Arun District Council
Arun Civic Centre
Maltravers Road
Littlehampton
West Sussex BN17 5LF
Planning & Building Control General Enquiries
Tel: (01903) 737756 Fax: (01903) 730442
Dx: 57406 Littlehampton
Minicom: 01903 732765
e-mail: planning@arun.gov.uk
website: www.arun.gov.uk/planning

Application No: R/90/22/HH
Site Address: Kingfishers 10 Fosters Close Rustington BN16 2TL
Description of works: Single storey side garage extension, front porch extension, hip to gable loft conversion including the installation of front dormers and rooflights and alterations to fenestration/openings.

Thank you for your internet representation made on 13th May 2022 which has been recorded as an objection with the comments as follows:

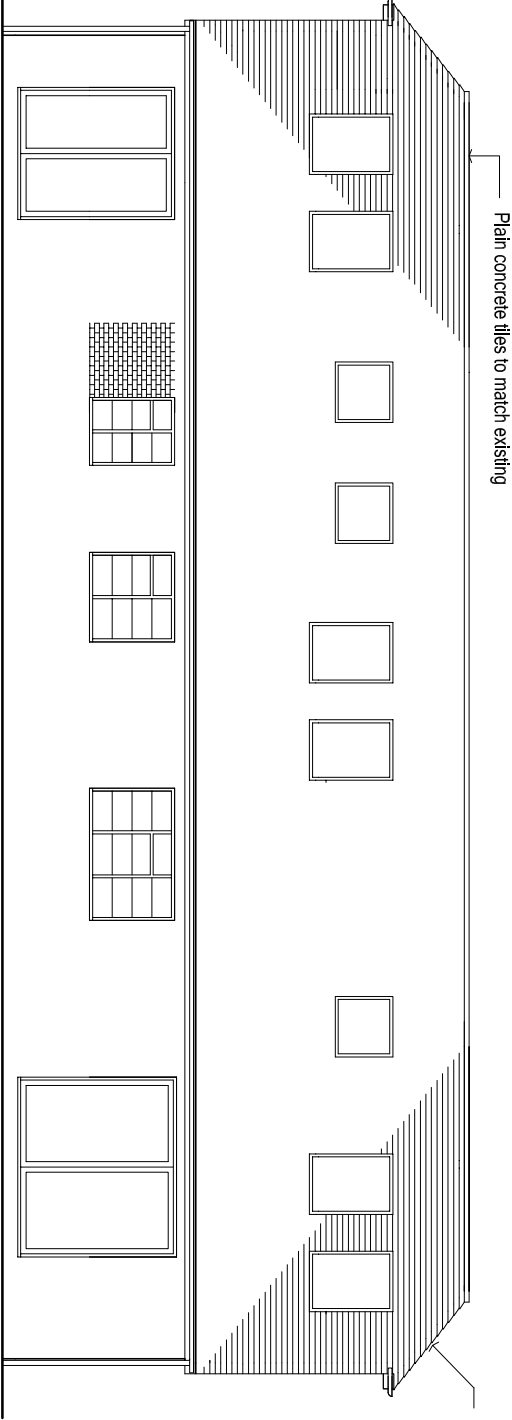
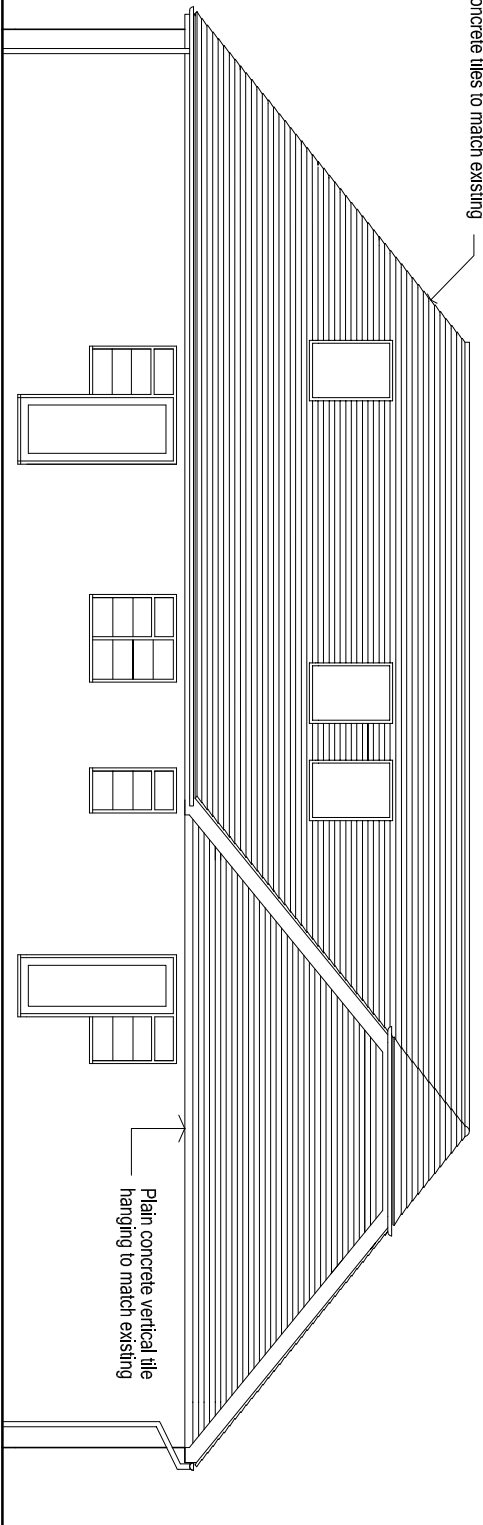
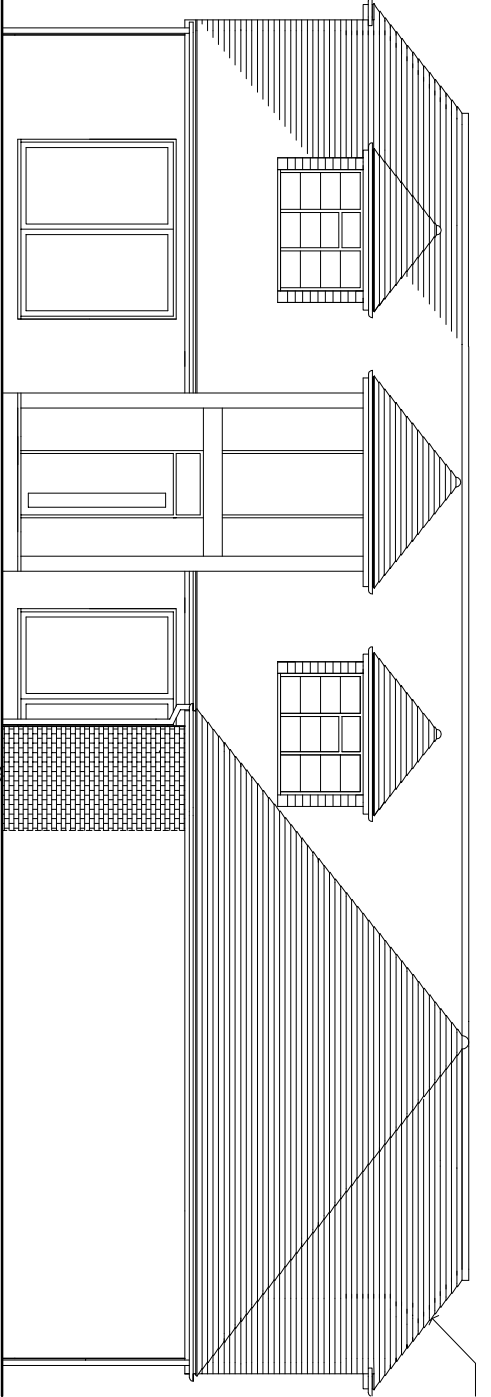
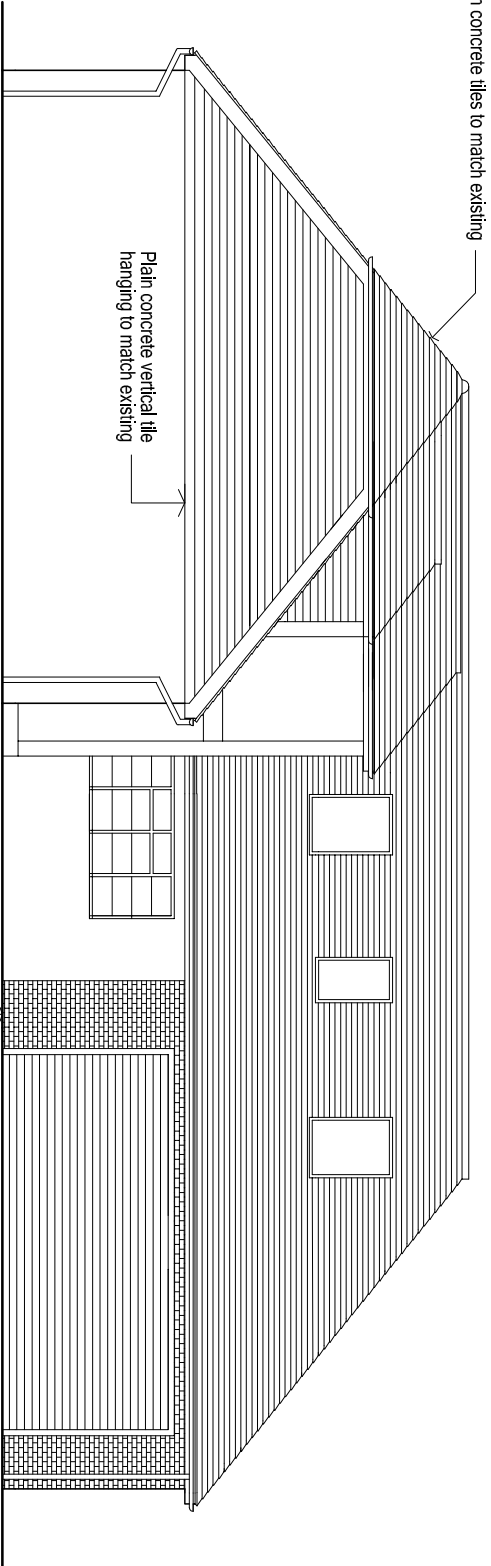
We are most strongly opposed to a raised roof being constructed, the proposed roof is designed with three windows in, which when viewed through will give a very clear uninterrupted view straight into our house wiping out 90% of our privacy within, the rooms in question which privacy would be seriously compromised are our three bedrooms, landing area, bathroom & shower, the full width and depth of our lounge, Kitchen and dining area, and hallway and both balconies, plus the majority of our garden, patio and pool.

The East wall of No10 Fosters Close is built just over 2 metres from my boundary
